Subject: RE: Solar Park - Land at Barnham Court, Church Lane, Barnham FAO: Richard Temple

Please find attached an amended and updated CTMP that the agents have compiled mainly in order to avoid having to discharge the CMP condition recommended by Allison.

Figure 2 - Routing Strategy

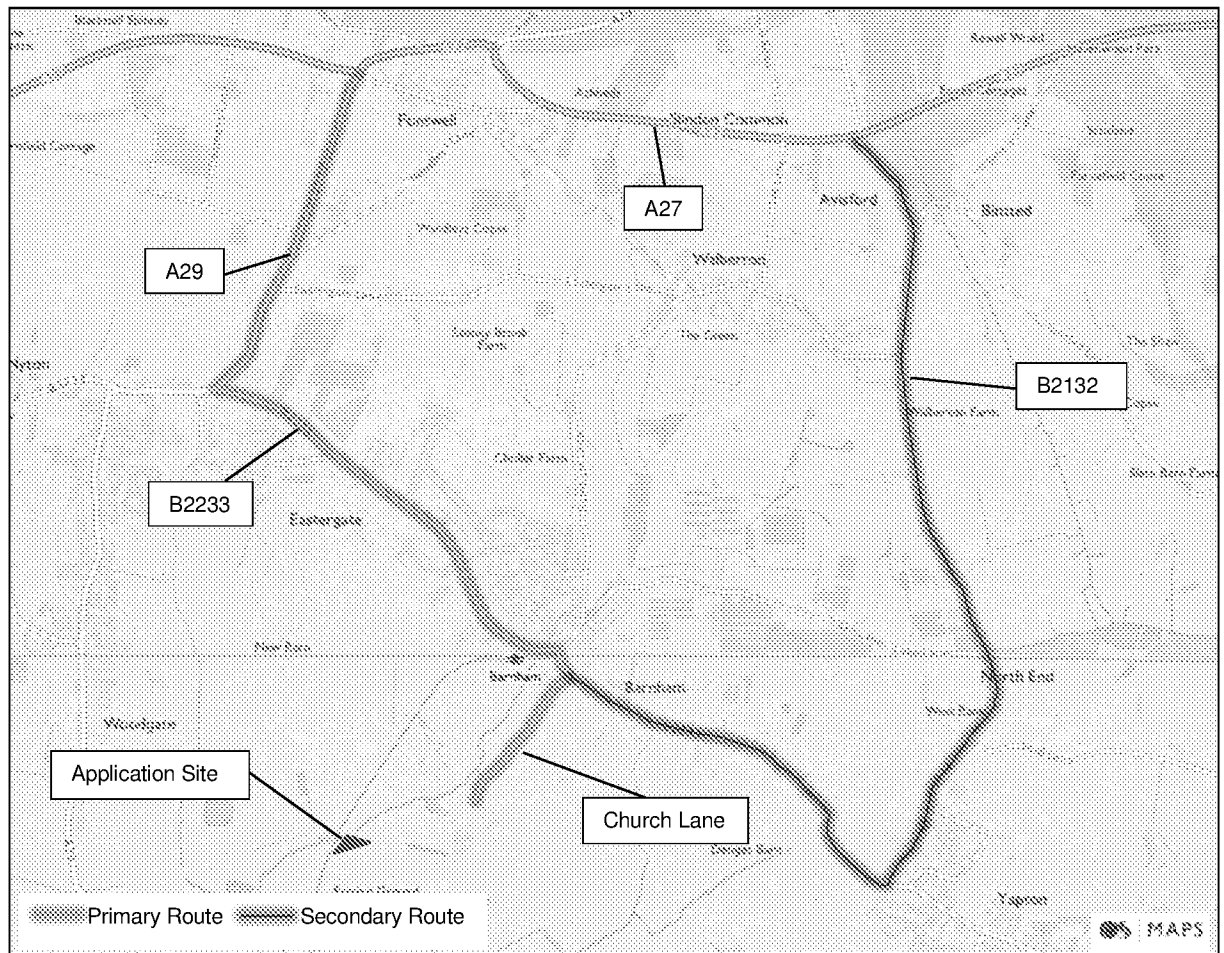
This still does not address the matter of the route to be taken after passing Barnham Church and in particular whether it will run along the north bank of the canal or the south bank and where it crosses into the compound. Scant consideration is given to RoW footpath users safety such as having banksman when crossing the public footpaths.

The Barnham Link cycleway reaches and ends at the Murrell Arms, not opposite the church gate _Church Lane is part of it - and there is no layby north of the Old Rectory: it's a patch of highway verge that has been run on by parking cars. It has no substructure to support the weight of HGVs.
